Please upload the below to the above applications. Conservation Officer comments.

Y/105/19/PL & Y/106/19/L

The proposal is for the conversion of, and alterations to, existing barns to create 3 dwellings, along with the erection of car barns, a store, a replacement pump house, demolition of a C20 barn and associated landscaping and parking.

Proposed Section

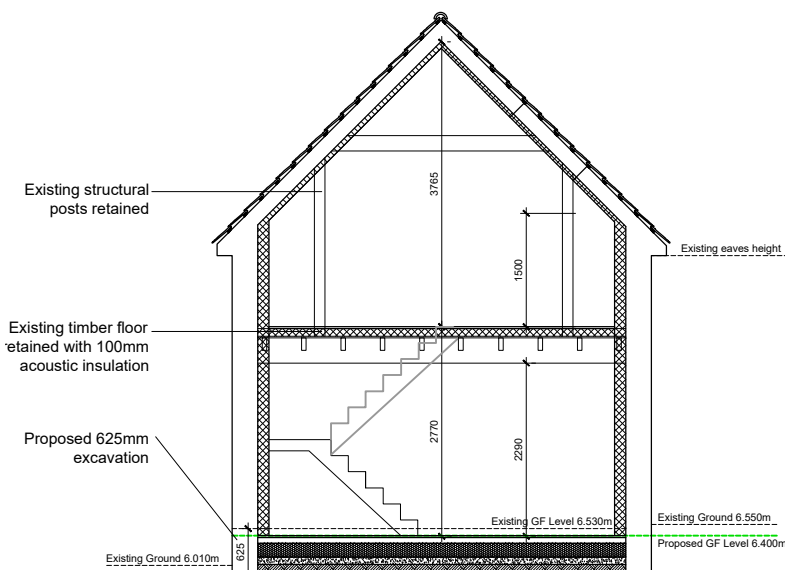
It is not clear how historic features including exposed roof trusses will be treated as part of the proposal.

Proposed North-West Elevation (A)

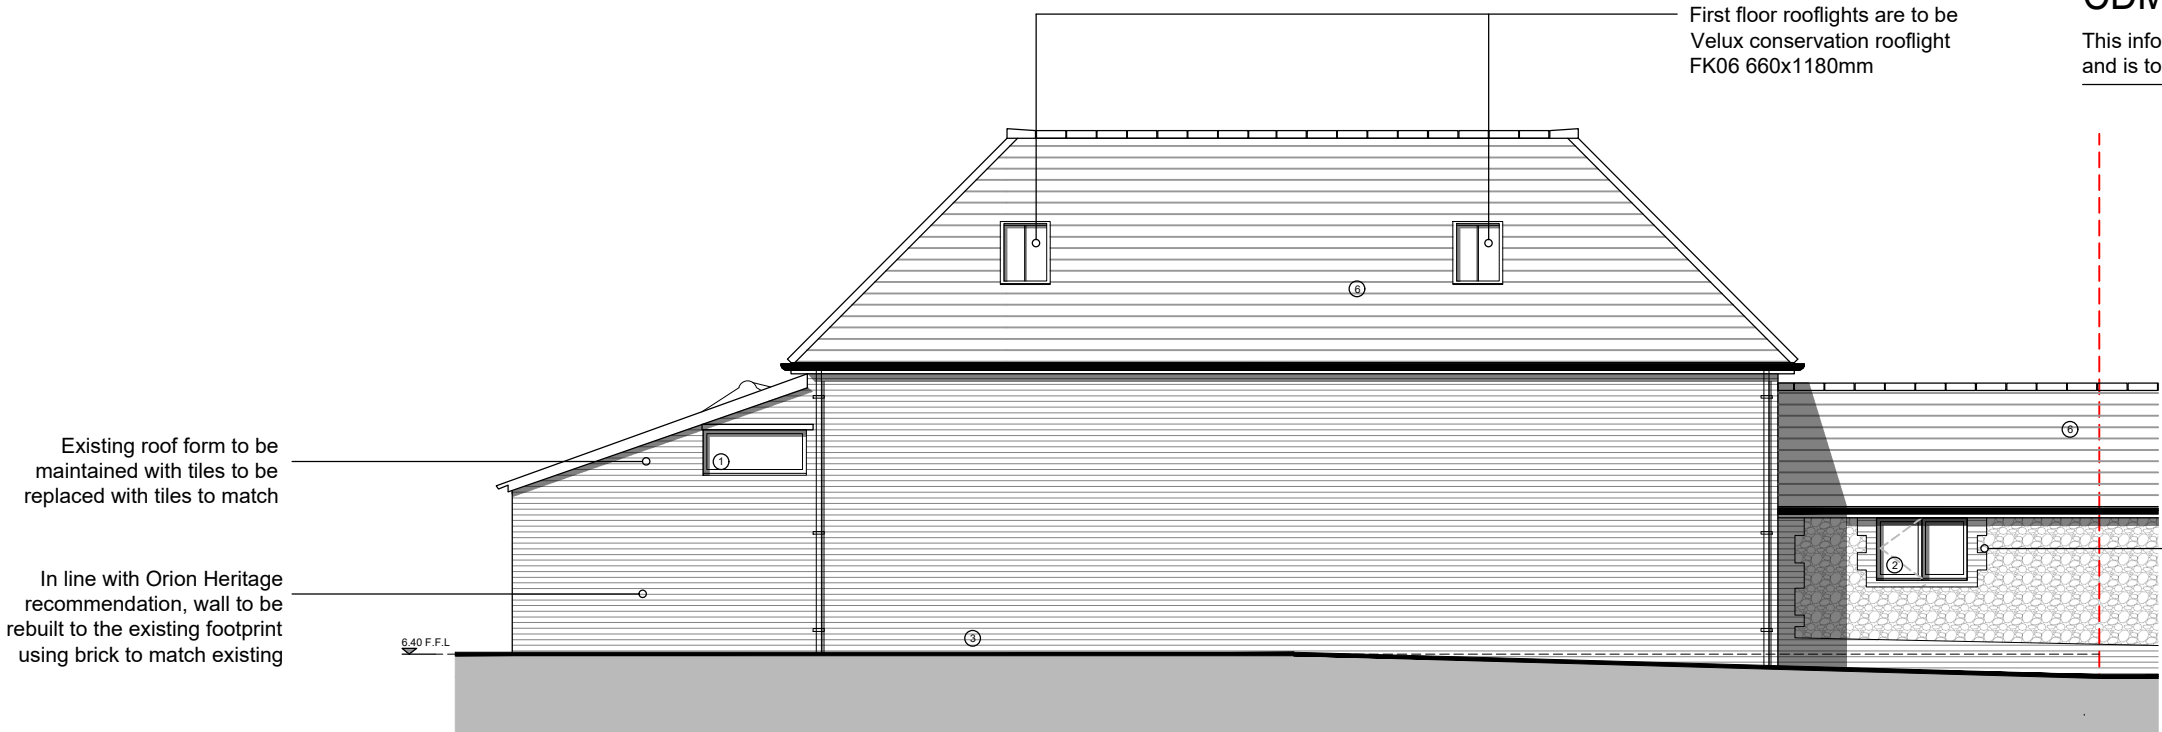
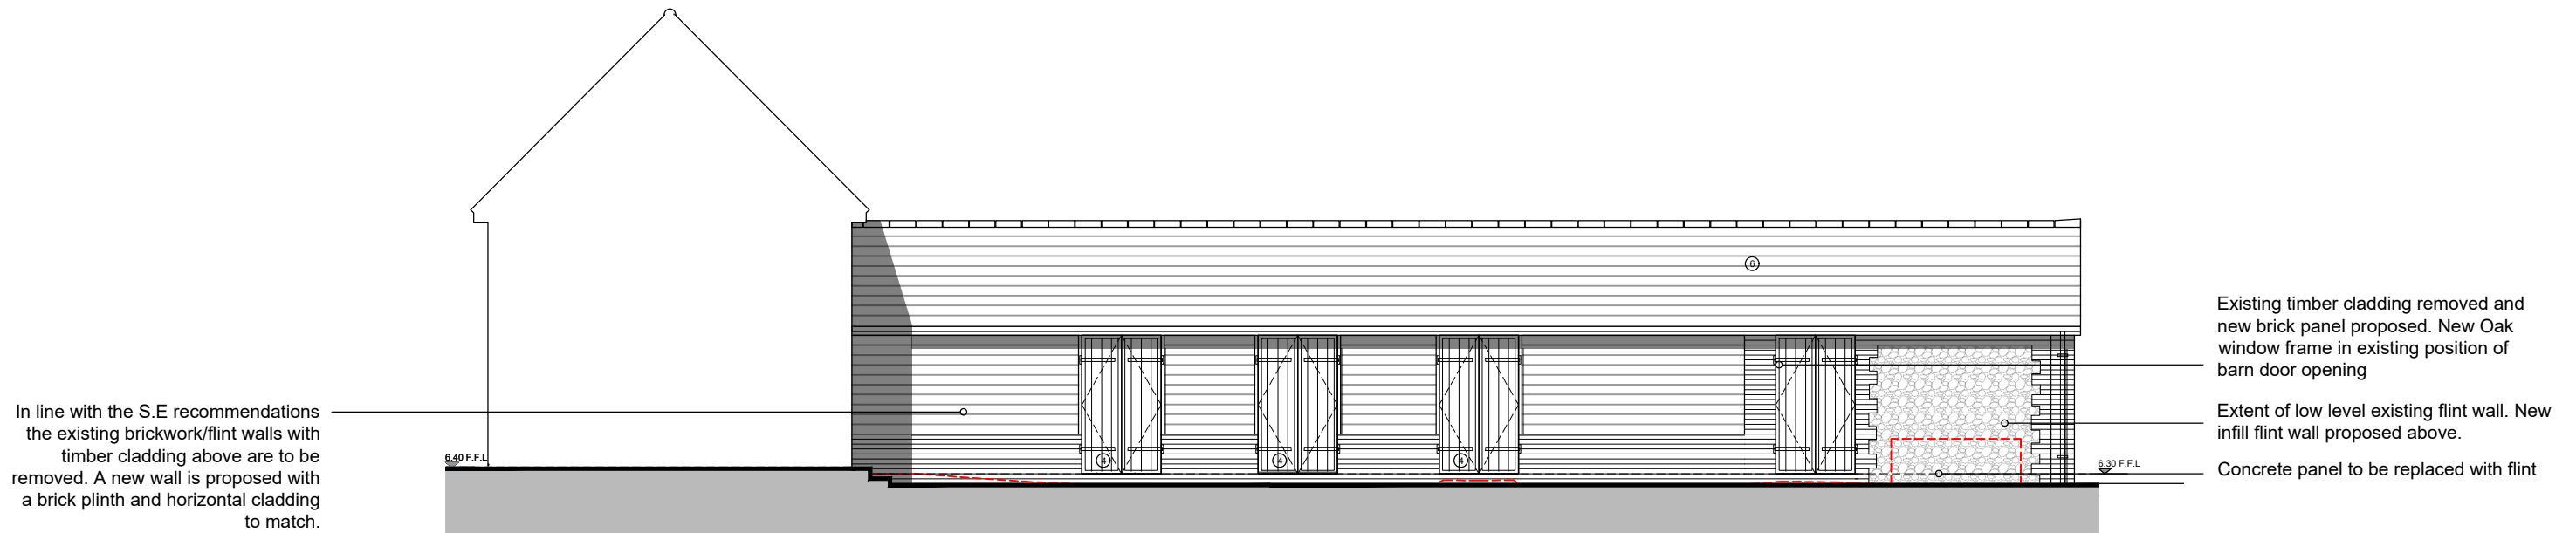
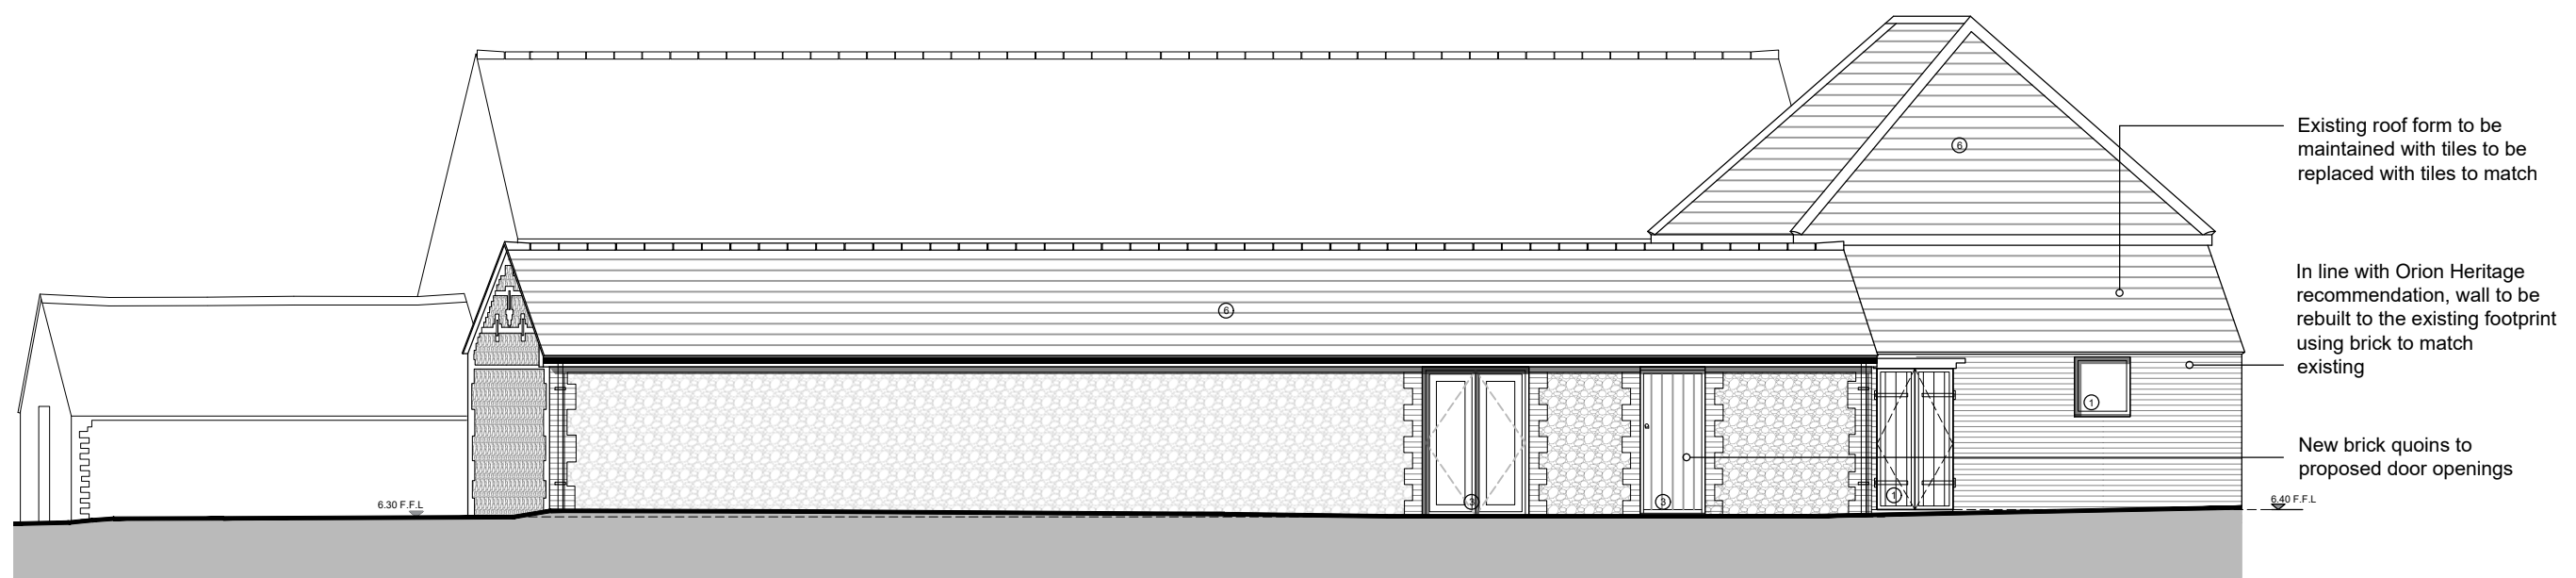
Likewise, in building one, it is noted that an elevation will be altered in order to expose the previous cart barn openings. Such a proposal is generally acceptable, but the design of the new elevation, which includes excessive amounts of glazing, should have a simple framed emphasis and be recessed as far as possible to allow a deep shadow line. Such an approach also minimises reflections to reduce the visual prominence of the glazing. This technique can also help to maximise light penetration into the interior. Details of the fenestration along this section of the elevation should be carefully considered in order to ensure that they do not dominate the elevation.

It is noted that the proposals will generally utilise existing openings for windows and doors. Such an approach is positive. However, it is noted that existing doors (or replacements) are not to be incorporated as part of the final scheme. This is unfortunate, as they retain character as part of the building, and are reminders of previous use. Where doors remain, they can be retained and used as shutters; doors can be fixed open in order to ensure that enough light is available to the interior of the building. If in a poor state of repair, they can be repaired or replicated.

There is some concern regarding the amount of rooflights proposed. Are so many necessary?

It is not fully clear what the proposed joinery will look like. It is recommended that they should not be stock doors/windows from a joinery catalogue as these are generally too "domestic" in style, and out of character with the original purpose of the building. As mentioned, glazing and frames should be deeply recessed in order to reduce reflections and visual impact.

Details of the proposed joinery will need to be provided to the council by way of condition. The windows/doors will need to be set back within the openings so that they are not flush and create shadow lines. They should also be of a simple design/appearance. Stairs should be robust in detail with plain newels and balusters to reflect the character of the barn
